# **APPLICANT'S RESPONSES TO RELEVANT REPRESENTATIONS AND ADDITIONAL SUBMISSIONS**

## **Drax Bioenergy with Carbon Capture and Storage**

**Document Reference Number: 8.3**

**PINS Reference: EN010120**

DRAWING NUMBER
 EN010120-PA-ES-6.2.18.1-Sheet3

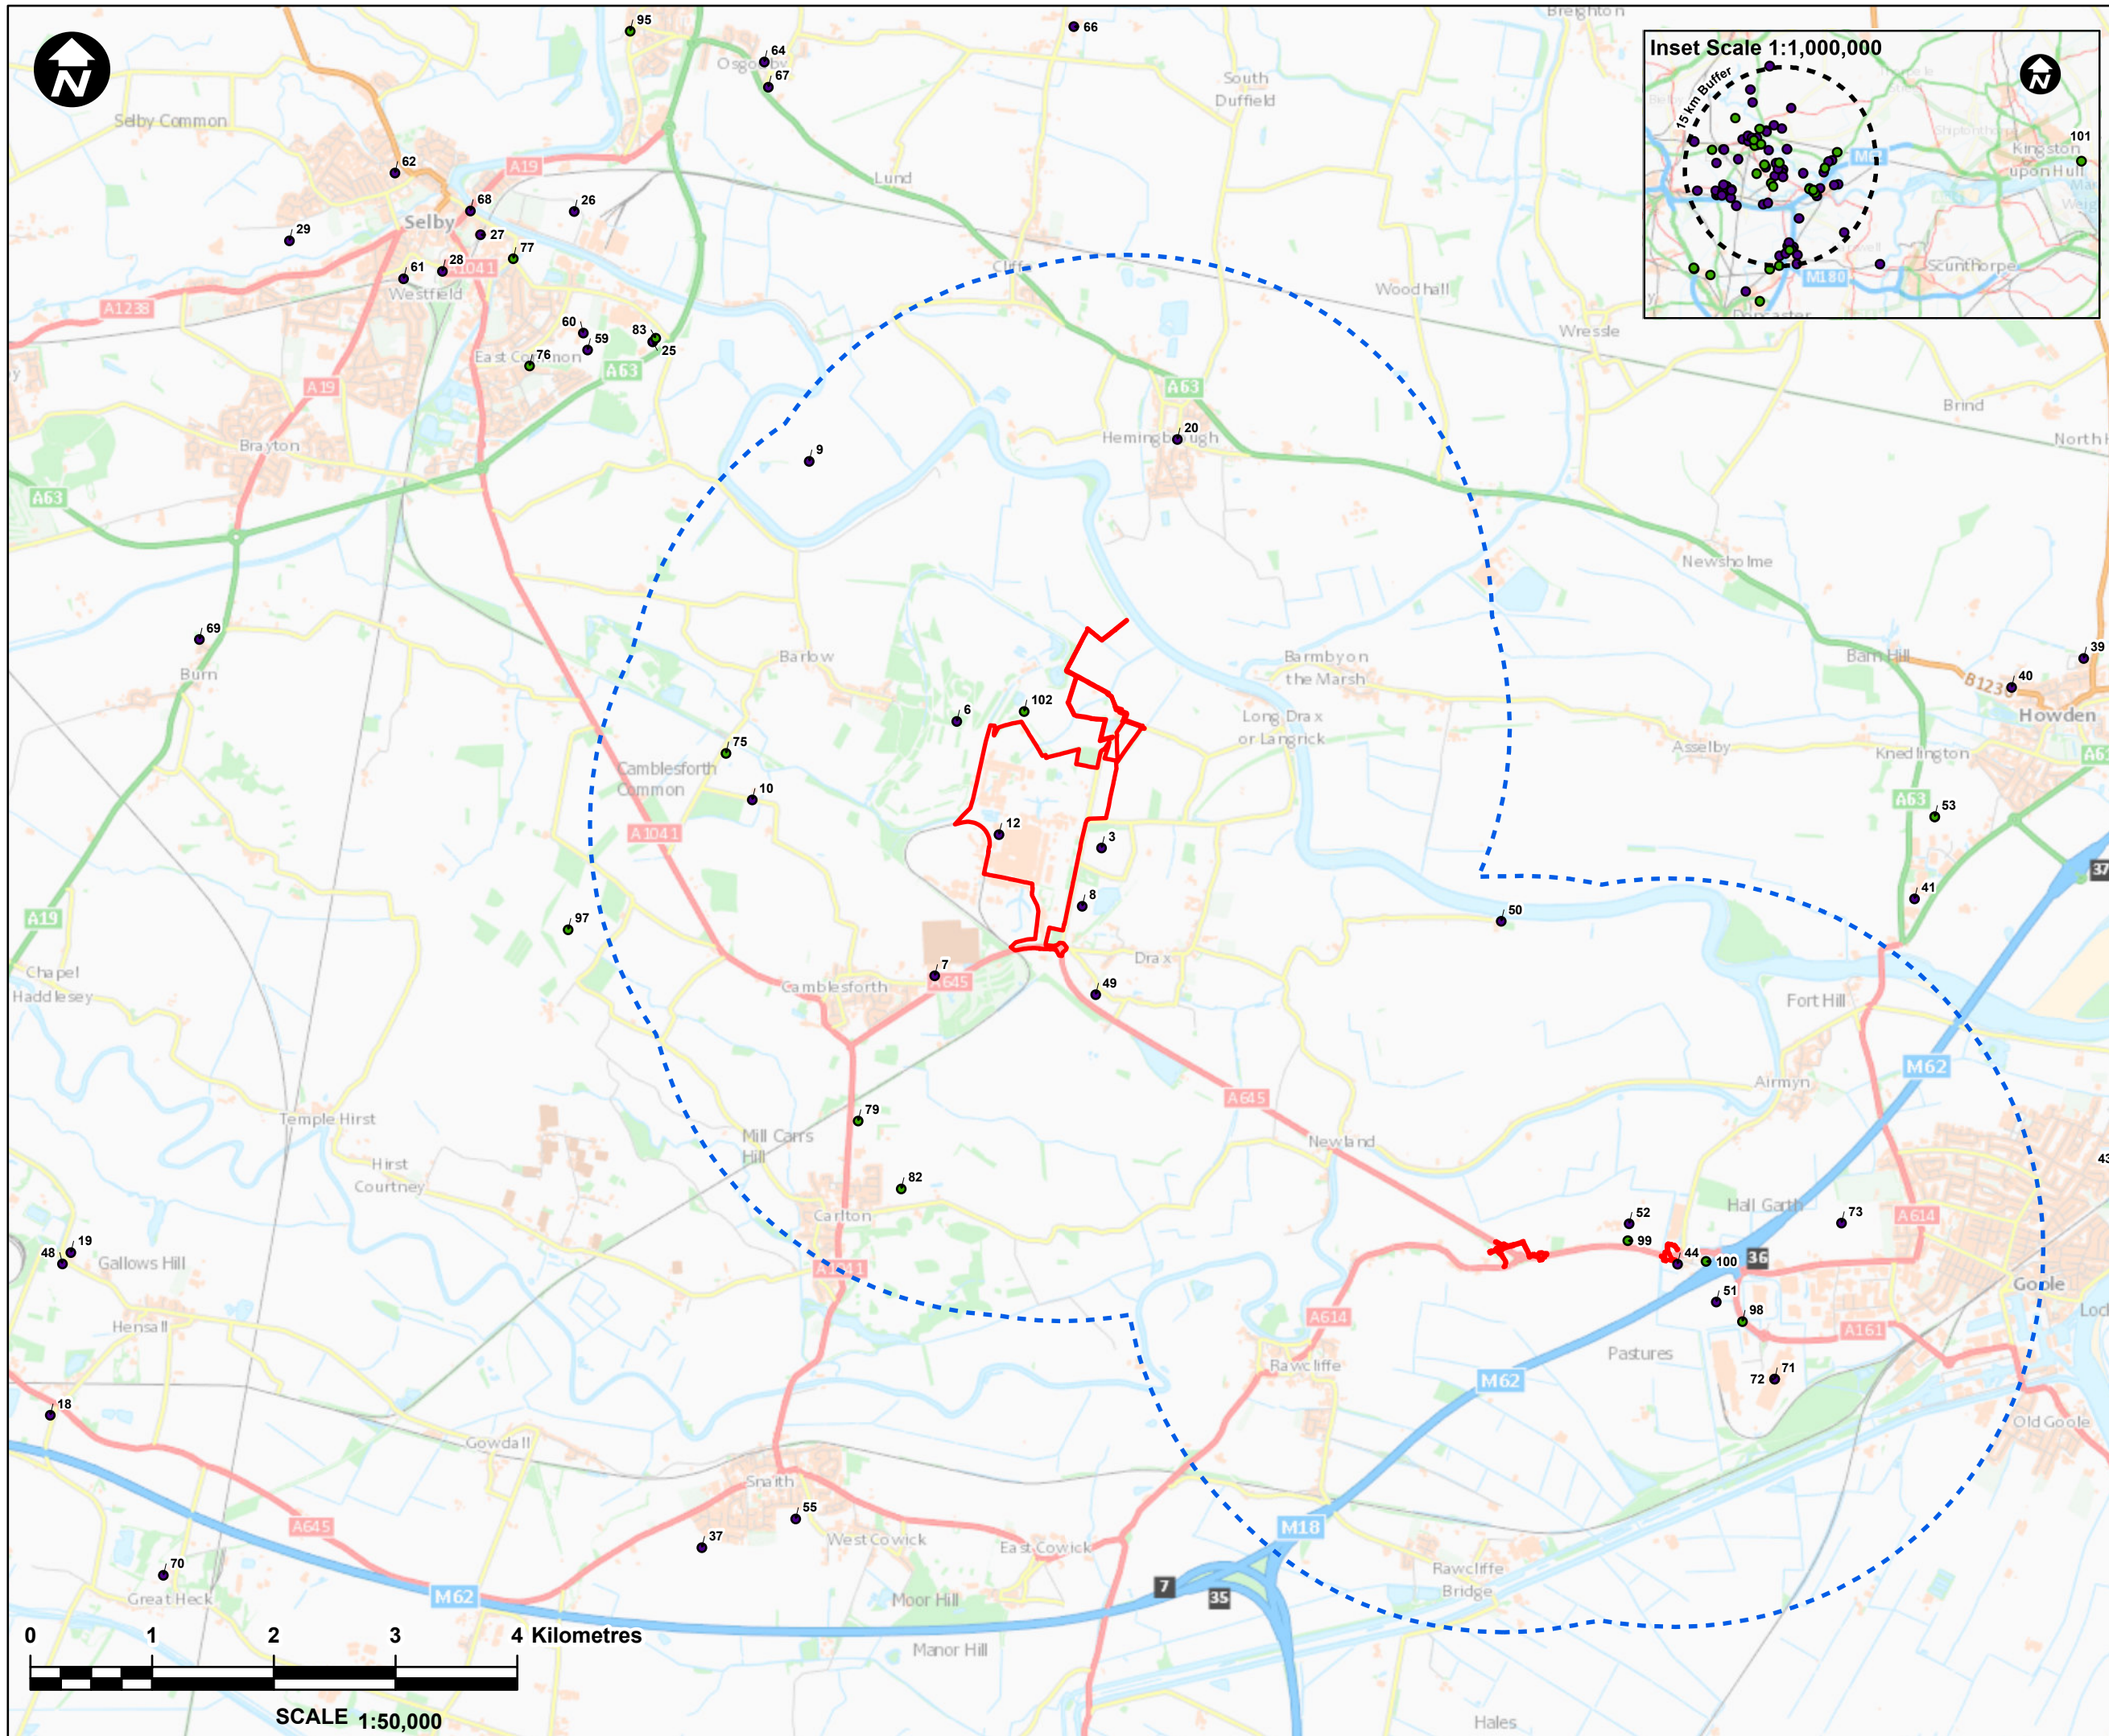
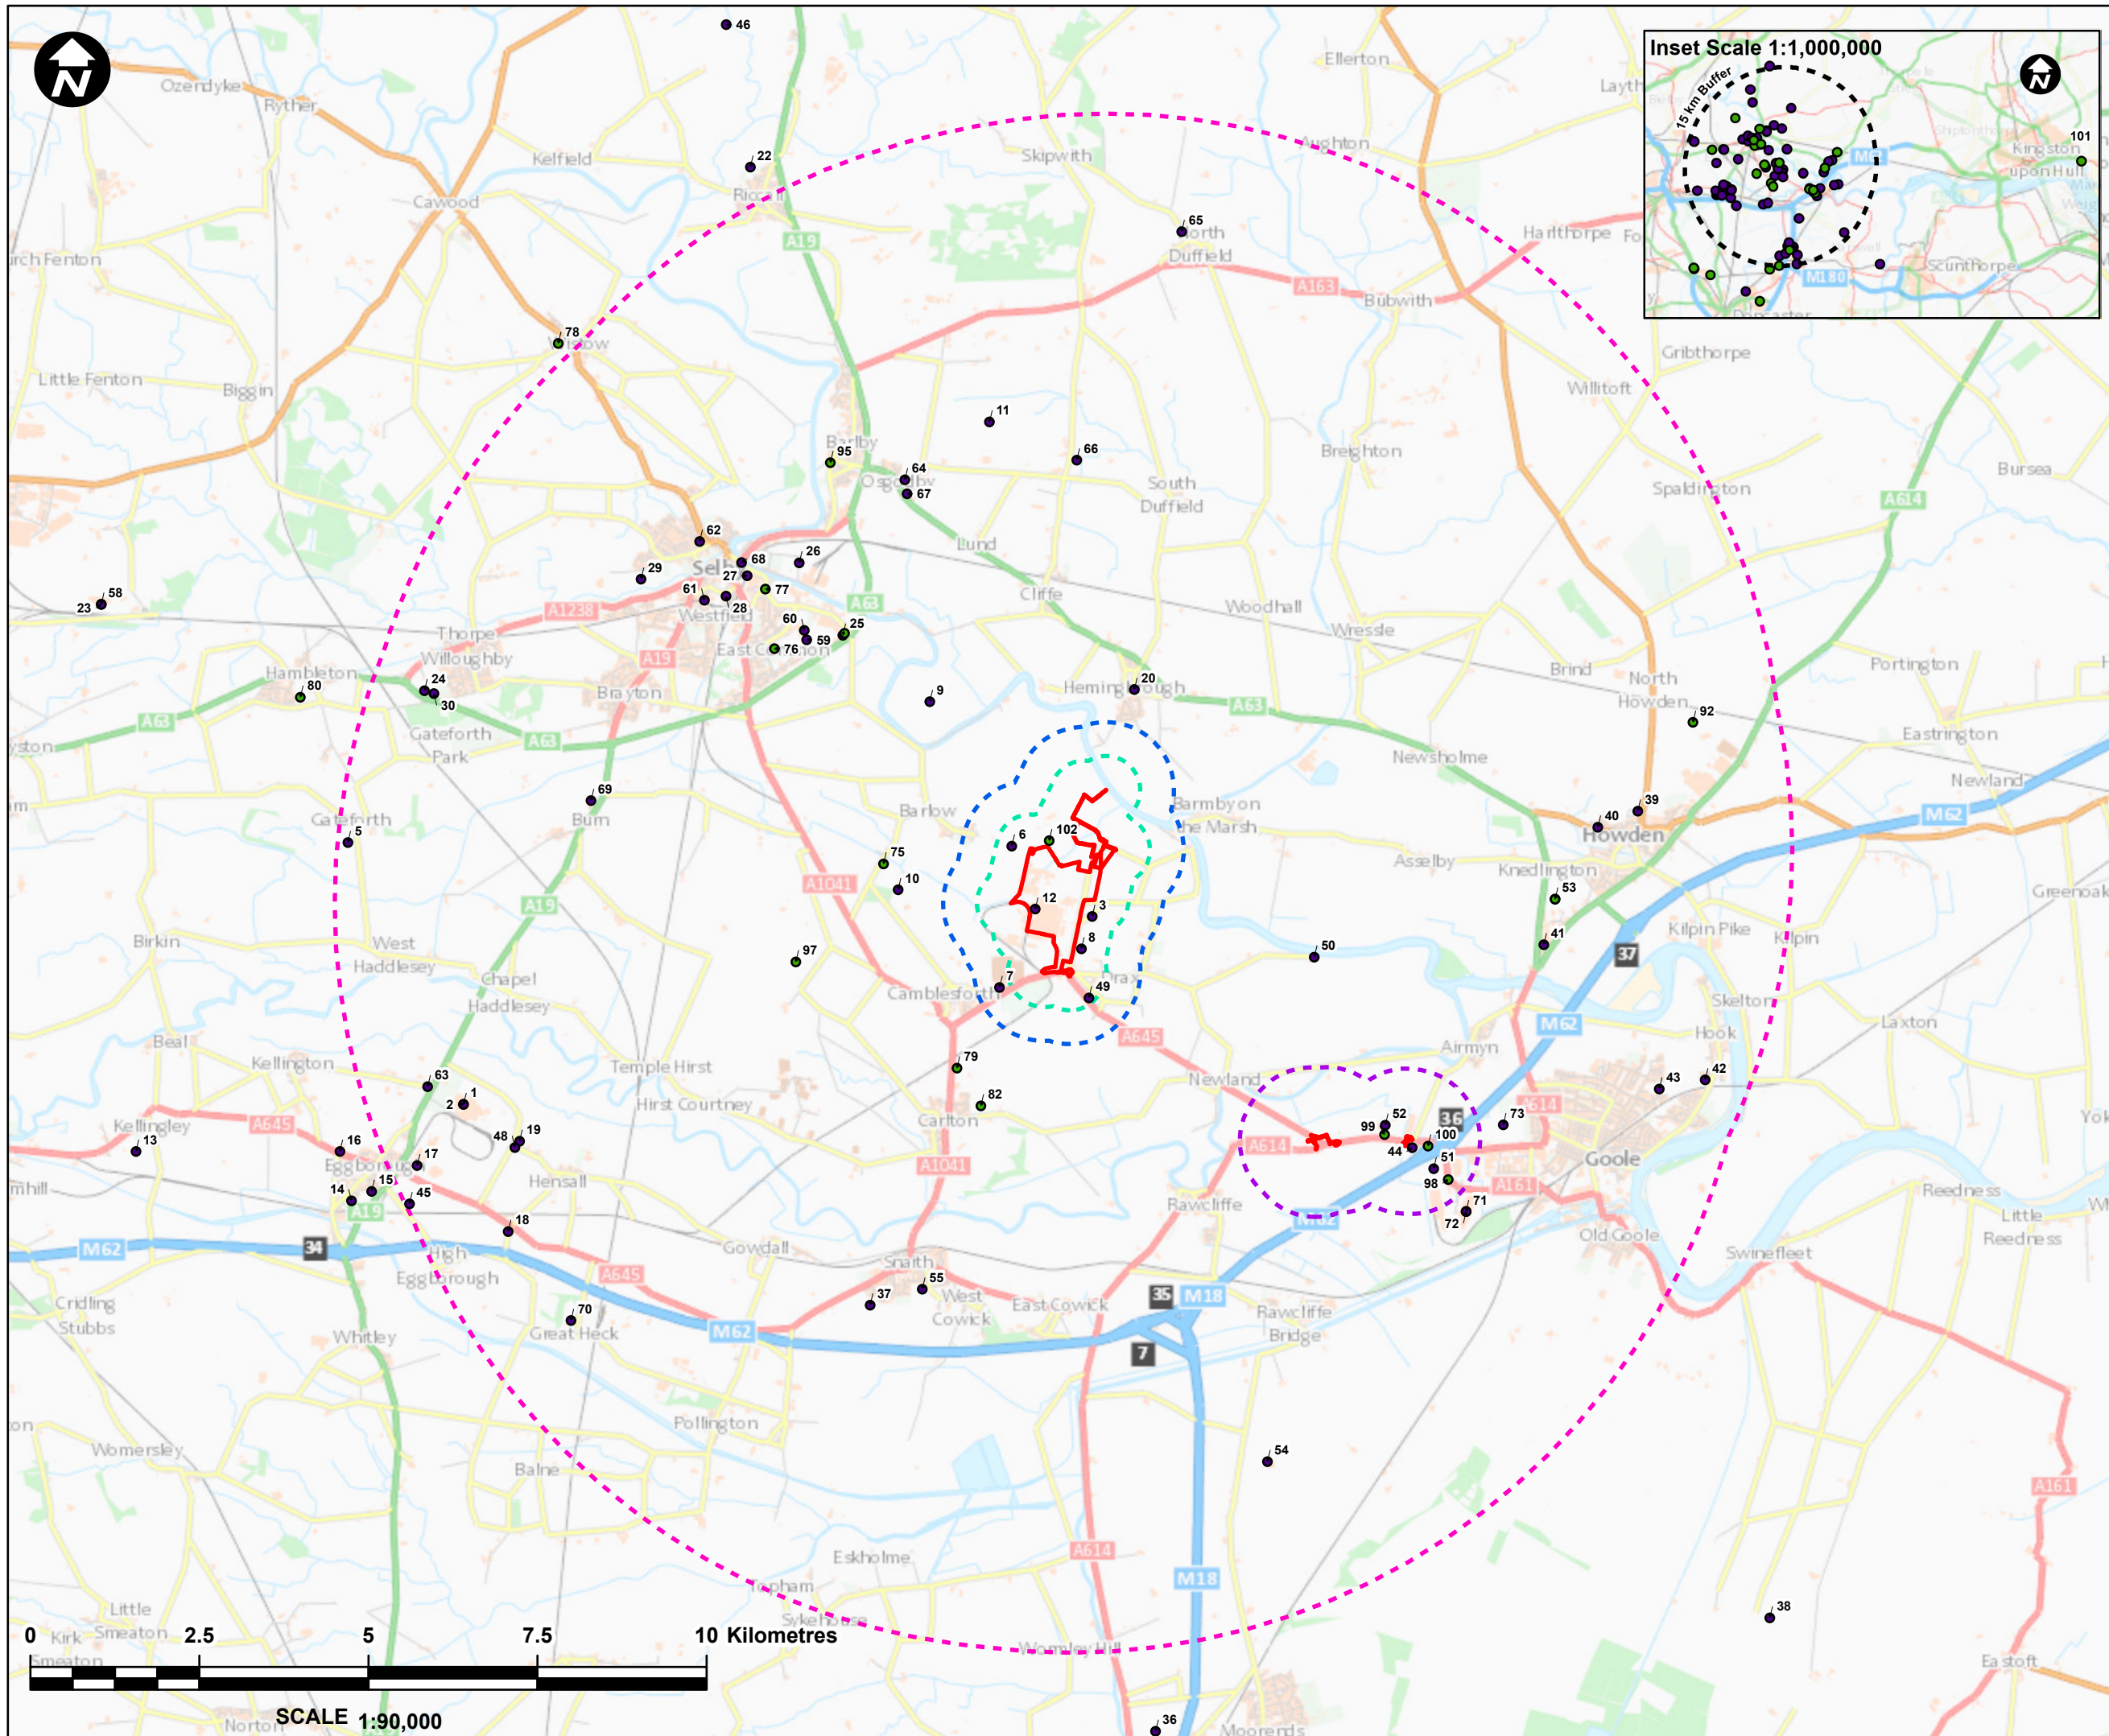
Response Ref.	Relevant Representation Comment	Applicant's Response
2.12. Cumulative	It has been noted that 6.3.18.2 Environmental Statement - Volume 3 - Appendix 18.2 'Short List of Other Developments' only contains 46 schemes, while the Environmental Statement refers to 76 schemes. It is understood that the applicant is aware of this issue and is looking to issue a corrected version for consideration.	This comment is noted and it is confirmed that the formatting error has been amended and a new version was issued to NYCC/SDC and other consultees on 1 September 2022. The updated document was reissued to PINS on 7 October 2022 (AS-013).
